466 Tremblay Road and 1440 St. Laurent Boulevard

Urban Design Review Panel (UDRP) Report

UDRP Date: June 5, 2026

Prepared for Groupe Oradev Inc.

SITE PLAN

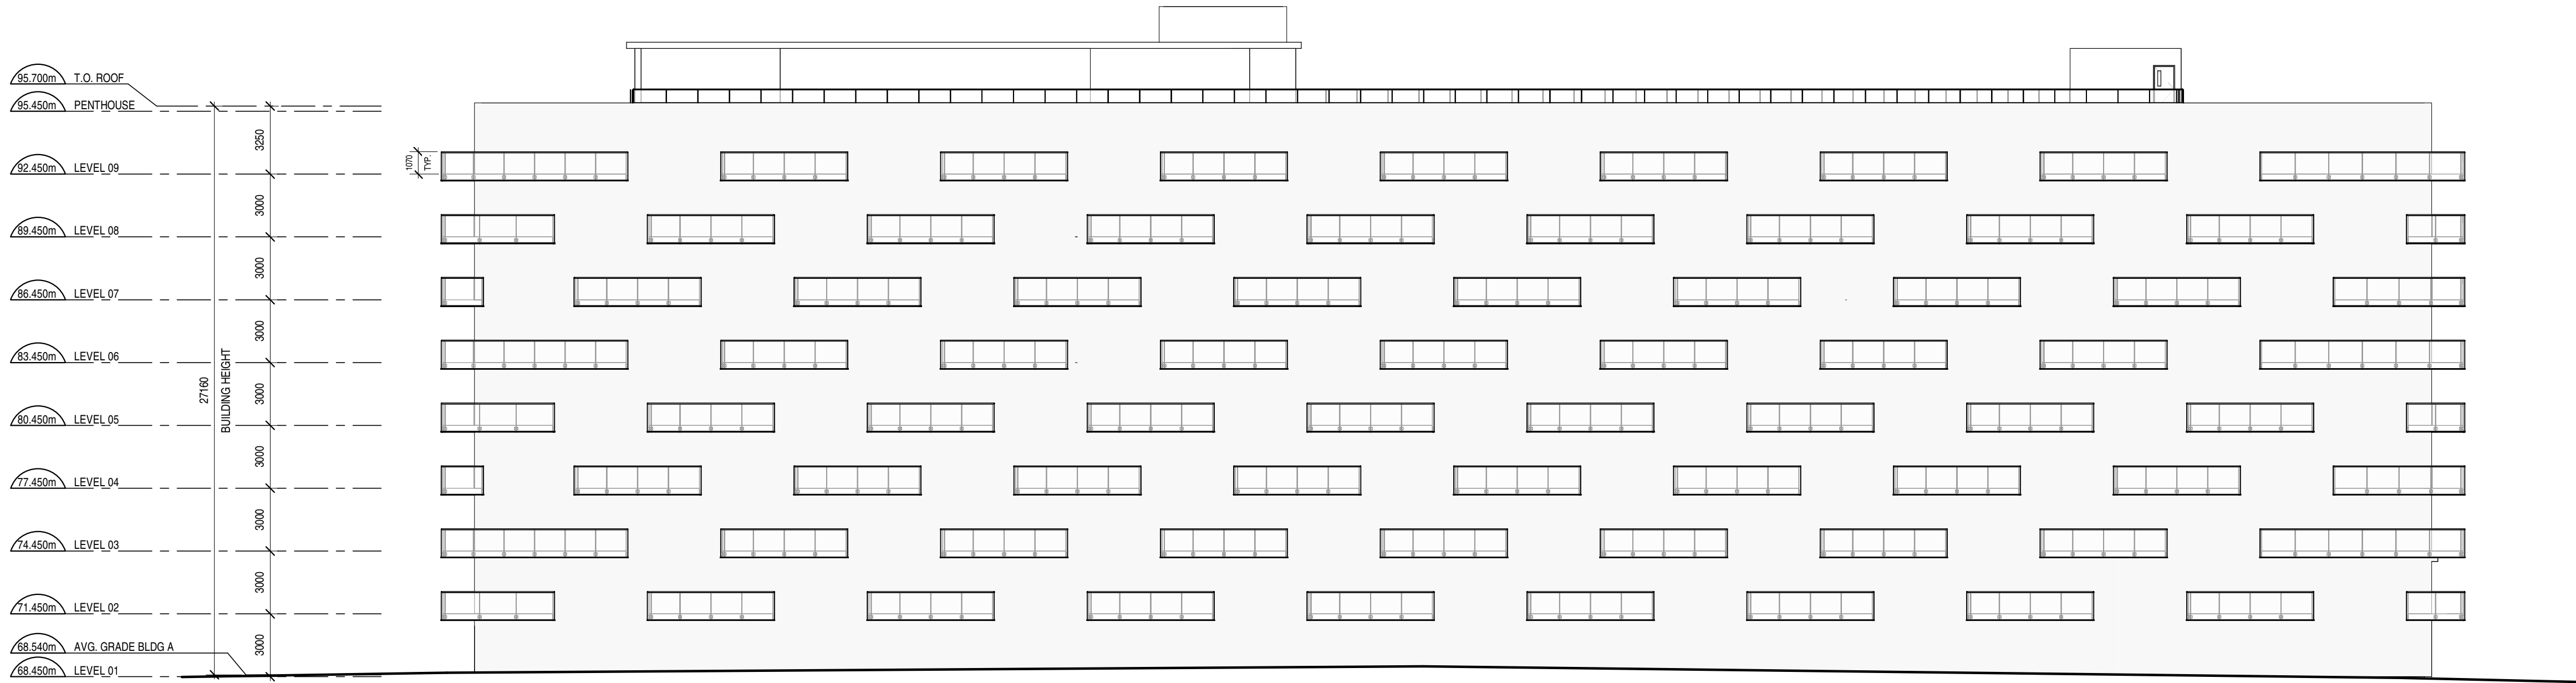
Site Design & Public Realm		
7	The Panel recommends exploring opportunities to reduce the impact of vehicular infrastructure, including ramping and loading configurations, particularly in proximity to Building B to increase the amount of contiguous, usable green space on the site.	We understand and appreciate the desire for increased soft landscaping. Nonetheless, there are practical realities that need to be addressed, such as the ability to enter the building in a location that is functional for residents. That said, we will continue to explore options, including the potential to cover as much of the parking ramp as possible.
8	The Panel emphasizes the importance of creating functional and well-designed landscape areas that support everyday residential use, including opportunities for seating, informal gathering, play areas, and tree planting.	The ground plane is not the only location that is available to residents for outdoor activities. The proposed project includes extensive roof-top terraces that include amenity lounges which can be used all year round. It is also worth noting that the site borders a green space to the south east, allowing additional opportunities for outdoor enjoyment.

EAST AND WEST ELEVATIONS
- BUILDING A

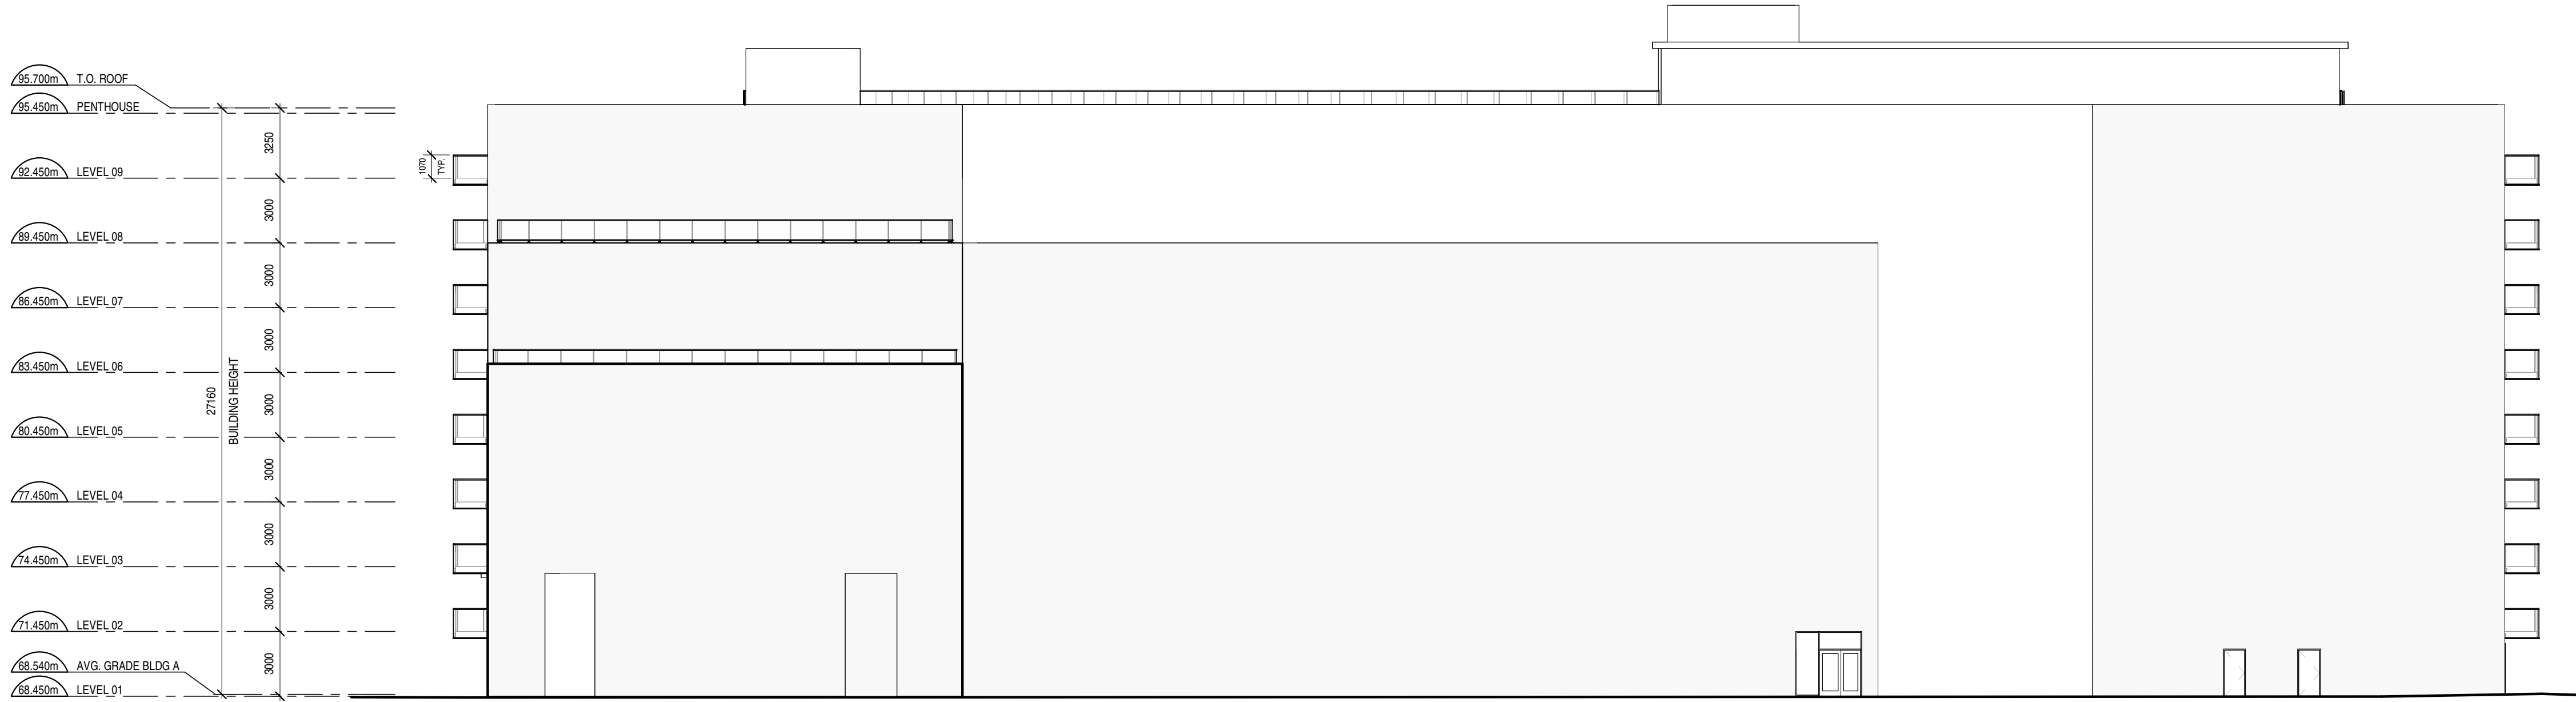
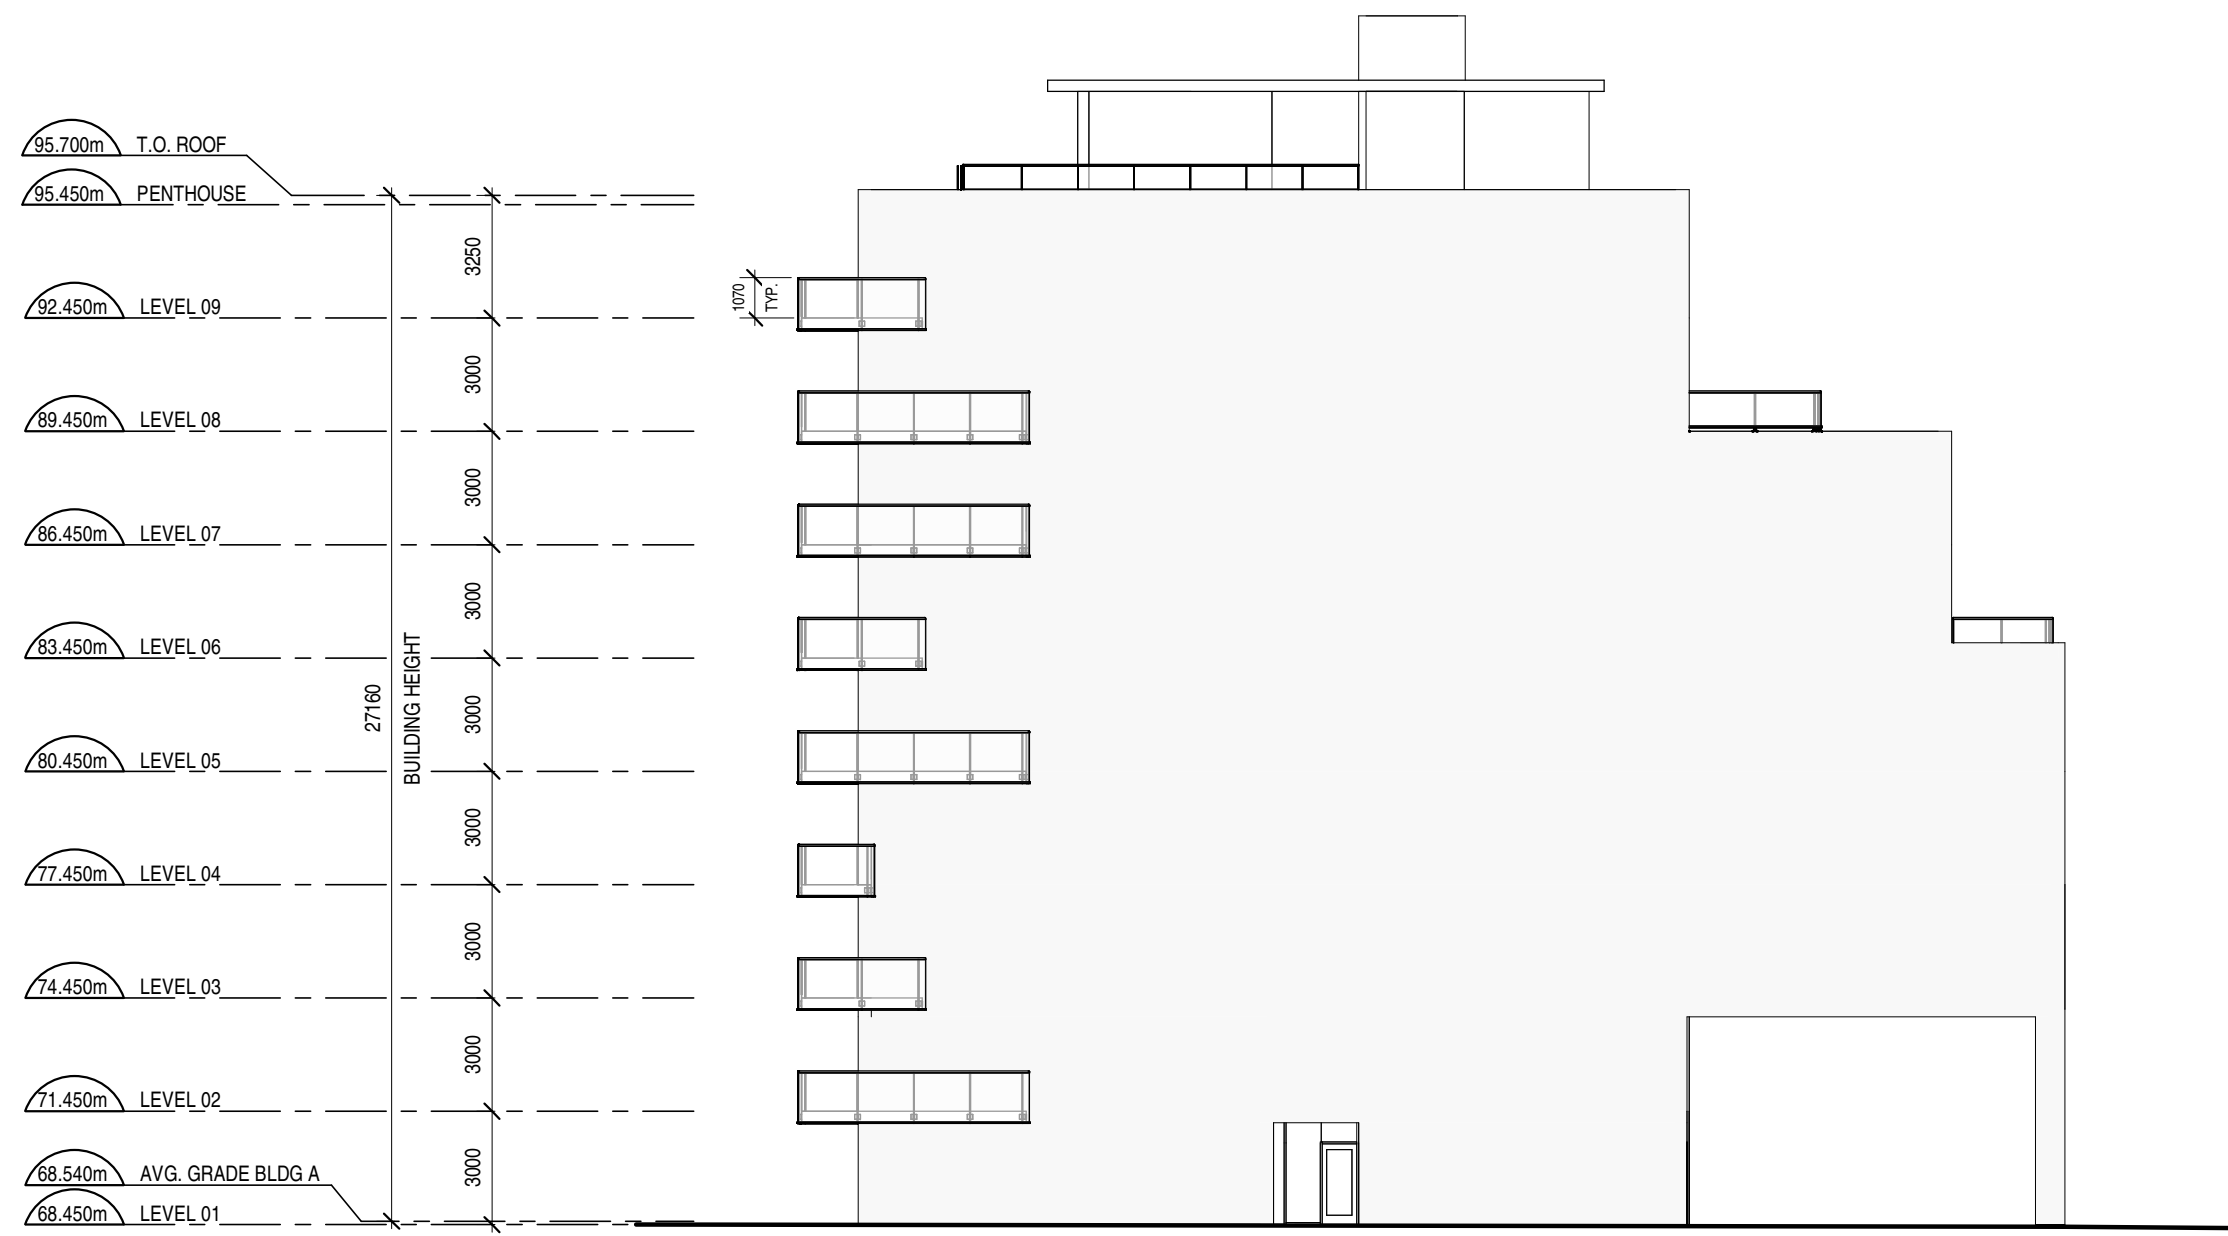
19	While there is no design to comment on, the Panel suggests simplifying the façade approach and reducing horizontal emphasis shown by the applied balconies. Greater use of vertical articulation is encouraged in order to better organize the elevation and reduce the perceived length of the building.	We will take these comments into consideration; however, we feel that vertical articulation will only increase the monolithic feel of the massing and will also increase the impression of the building's height. Likely the solution will be a strategy where the massing is cut into a series of volumes, with a few façade treatments being employed.
20	The Panel supports further study of roofline variation and upper storey stepping to reduce bulk and improve the relationship of the building to the sky.	Noted.
